Application no: H22/0827/99

Description: Erection of a two storey side
extension

Location: 200 Broadgate
Weston Hills
Spalding
Lincs

Amendment: Lounge and bedroom extended, plus revised fenestration

GROUND FLOOR PLAN

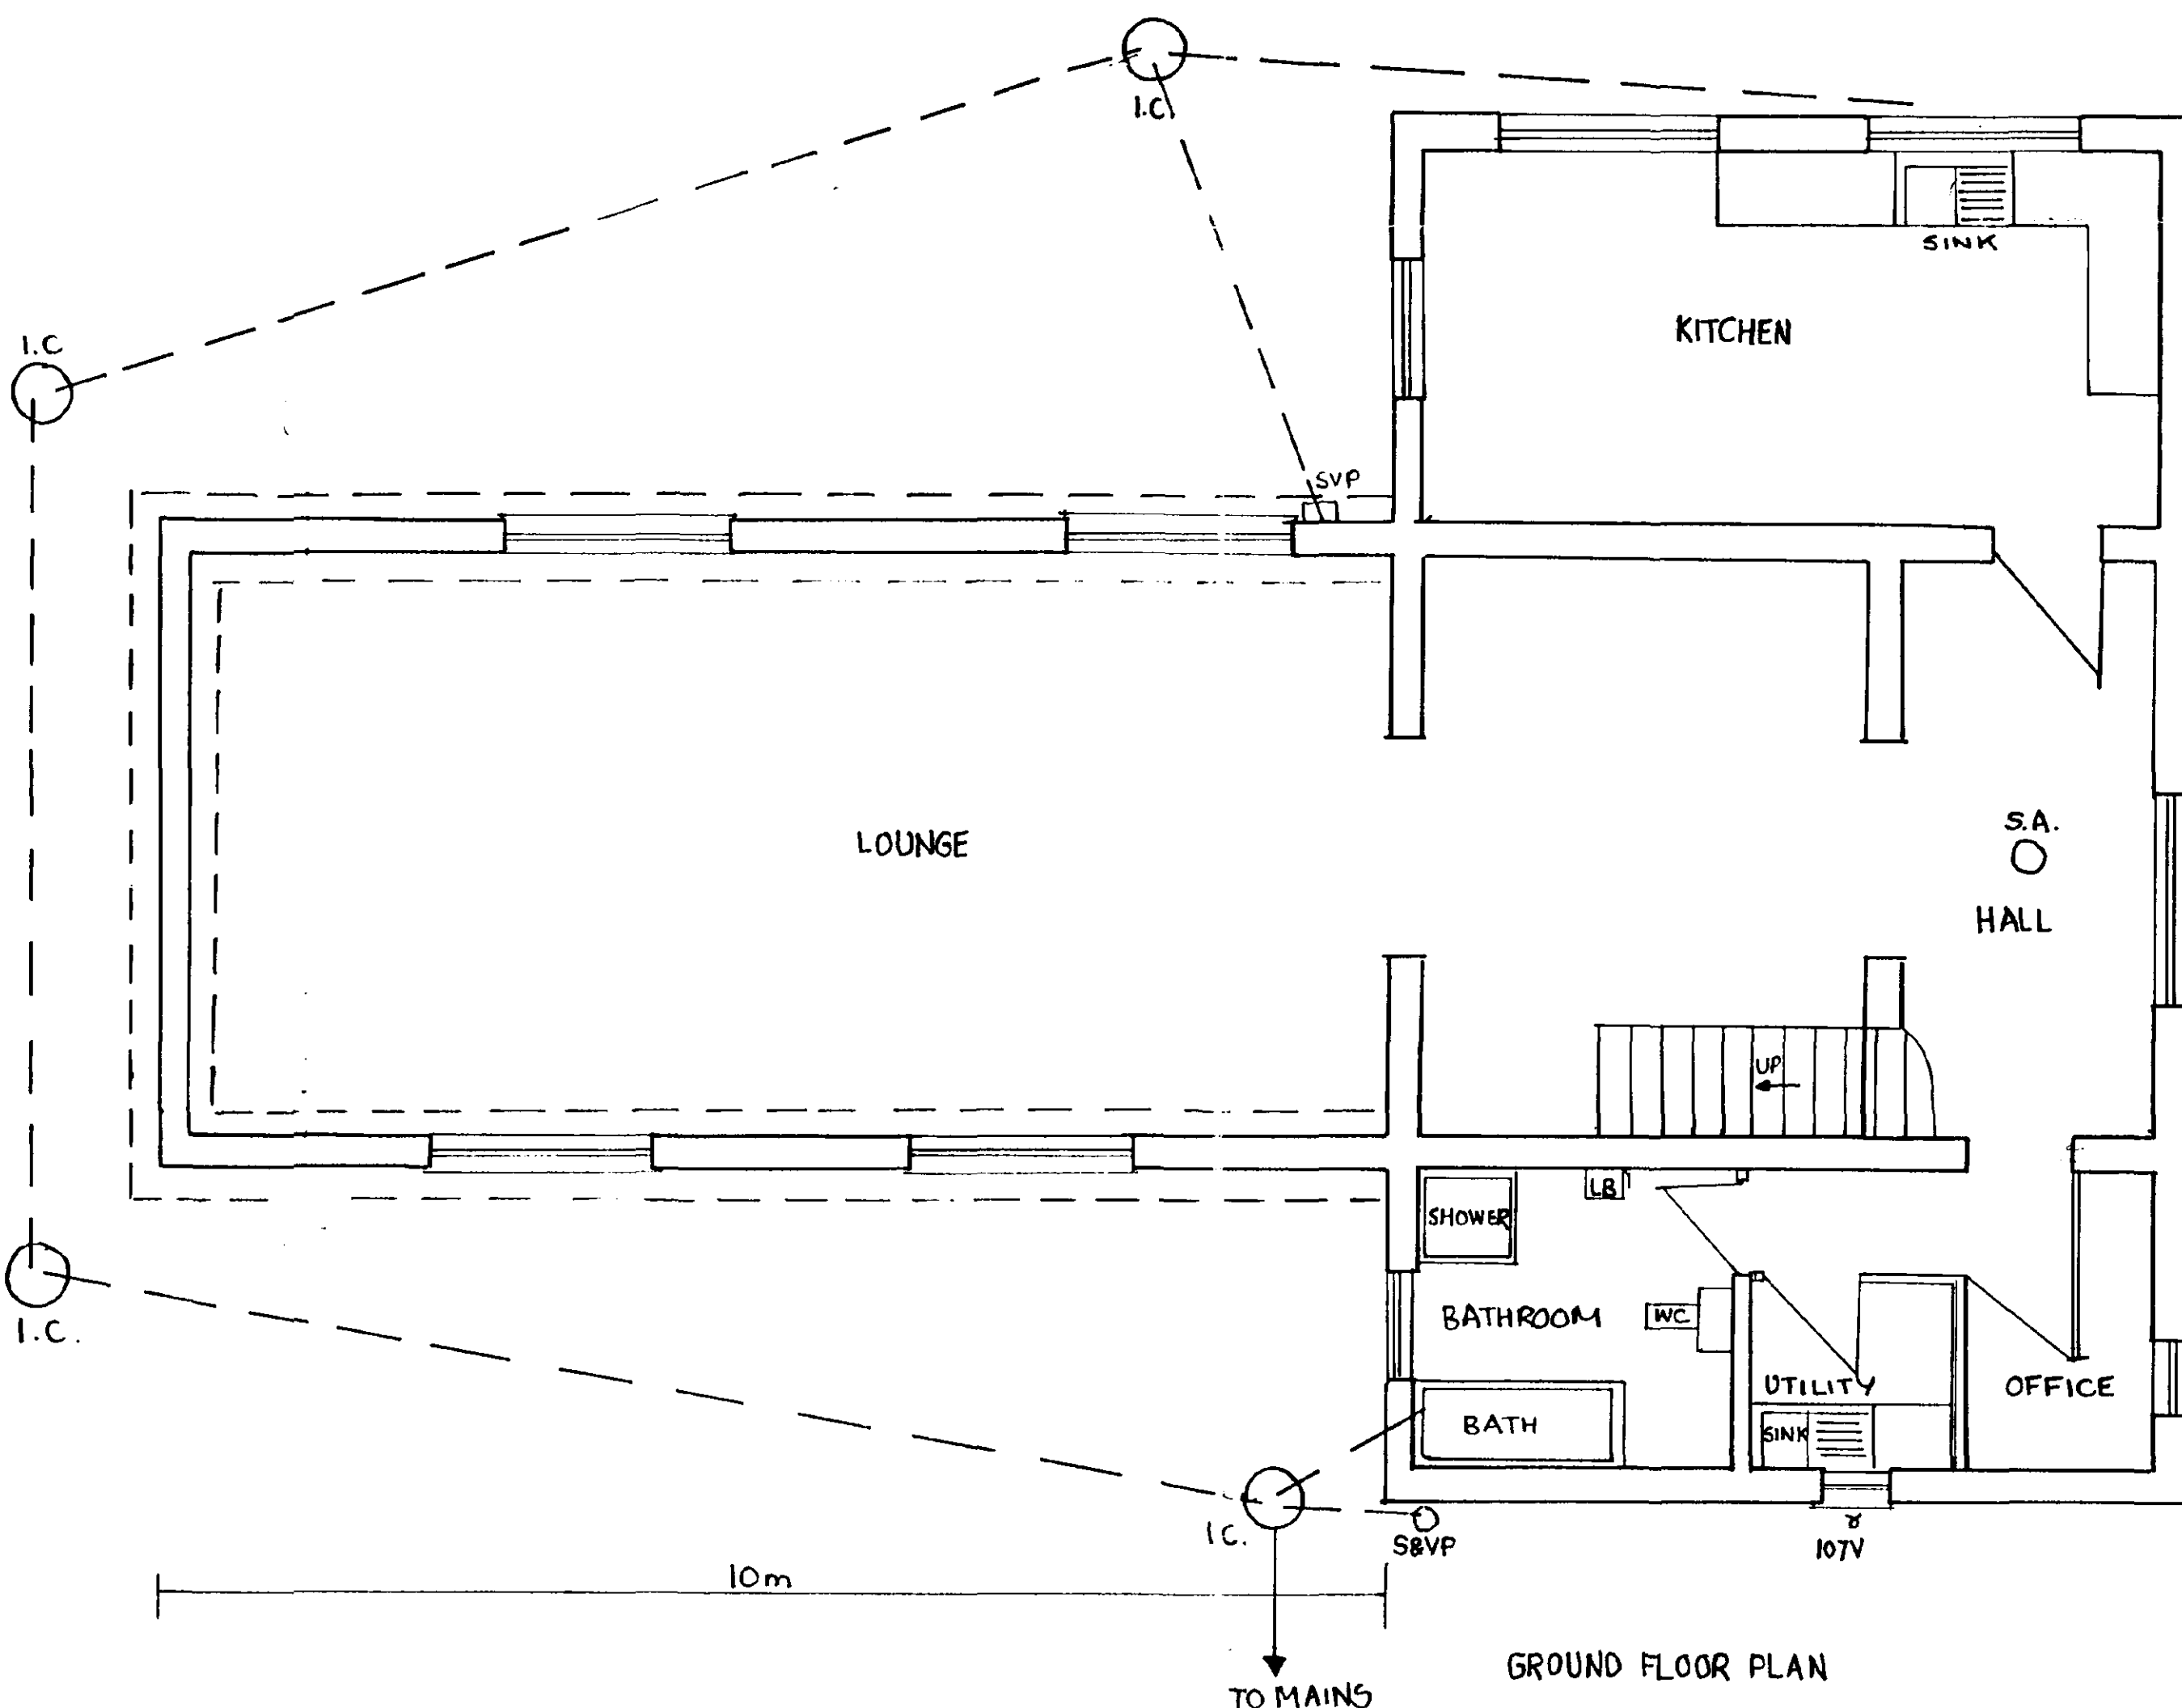
2.5m - two storey
Now proposed 10m
length of extension.

The amended details submitted in respect of the above proposal have now been considered and there are no objections to the amendment being implemented to the extent described above.
